# Markup Summary

## Steve Kuehster (4)

OVERLOT GRADING AND EROSION CONTROL PLAN

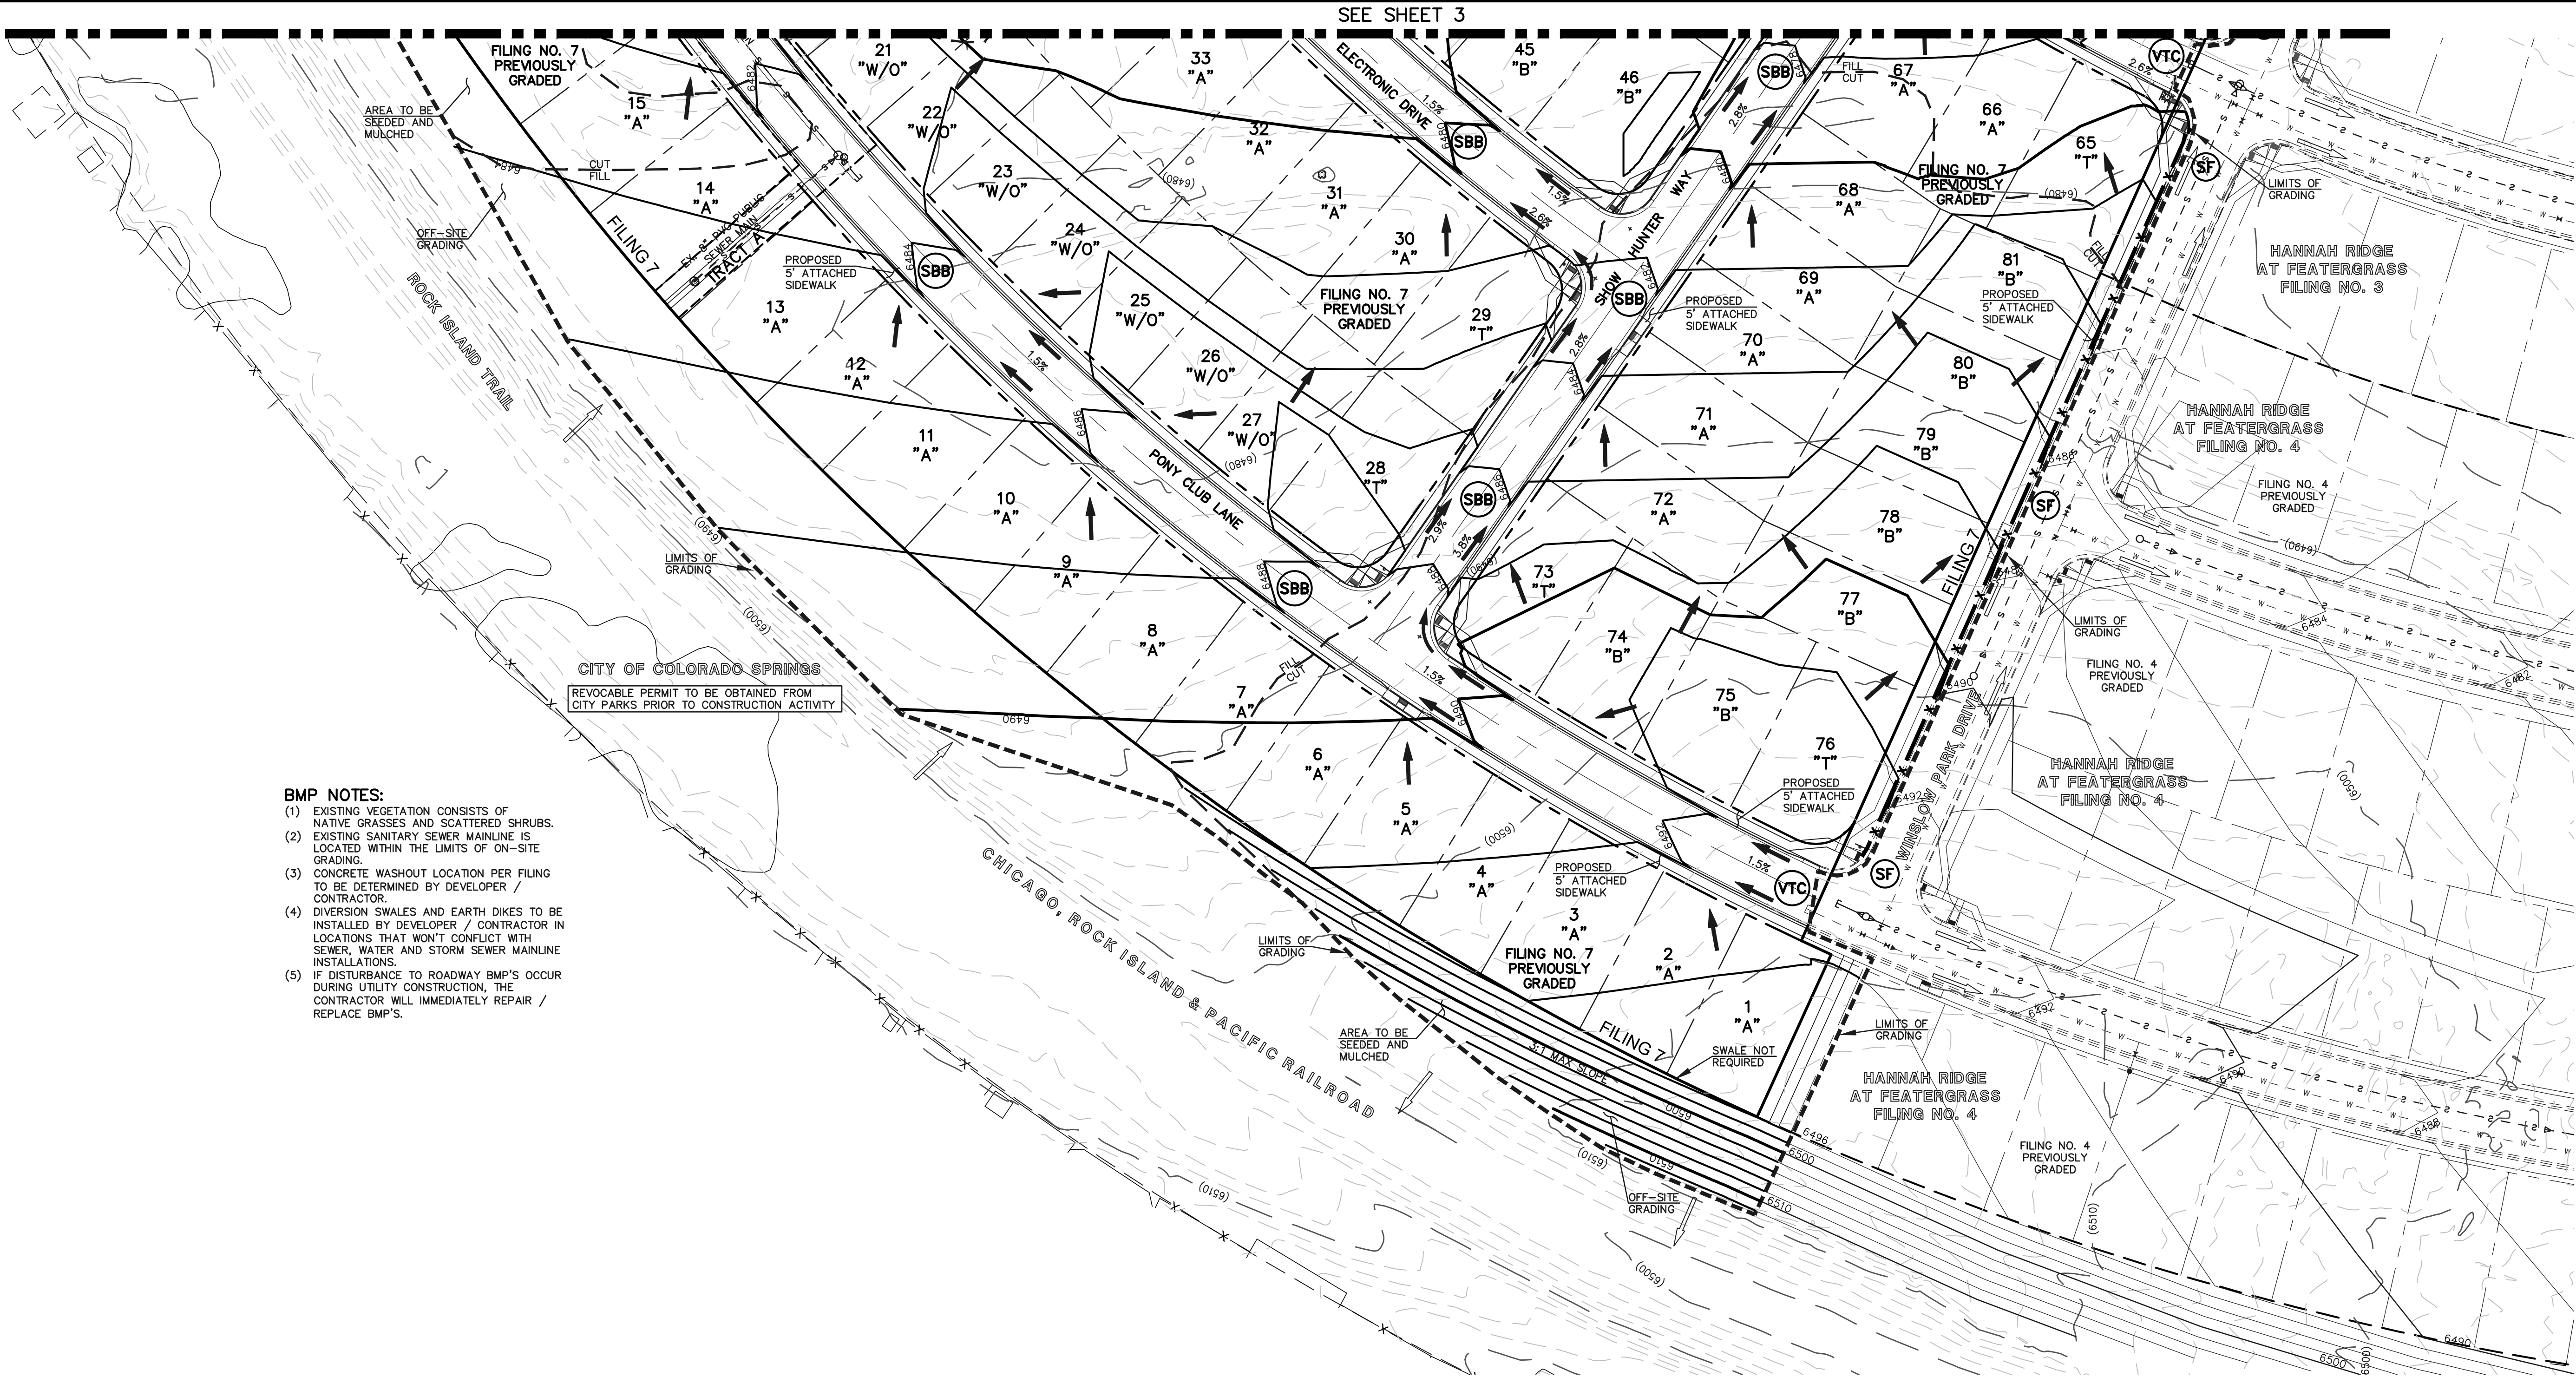
These BMP notes do not answer the previous comment:

It is not clear from reading both this and the Plans as to how sediment would be trapped by the One (1) TSB proposed on this site. EPC has made the comments that more controls need to be shown. Additionally, what is the phasing of the public storm sewer construction that gets stormwater to the main TSB, etc. during grading/construction/home building?

A follow-up phone conversation with Steve Kuehster to discuss the plan revisions submitted in December 2018 may have cleared up these comments. We pointed out the additional erosion control measures Steve requested were added to that plan set and in EPC review in January were most likely overlooked. TSB's and SBB's were added to control the runoff within Filing No. 6 and 7. The overlot grading will be phased to allow construction of Filing No. 7 including the stormwater quality facility within Phases 1, 2 and 3. Filing No. 6 will be constructed following build-out Filing No. 7 with all runoff being treated by the proposed SWQ facility. The last subdivision that will be constructed will be Filing No. 5. The improvements within Filing No. 5 will include the open drainage channel and concrete box culvert.
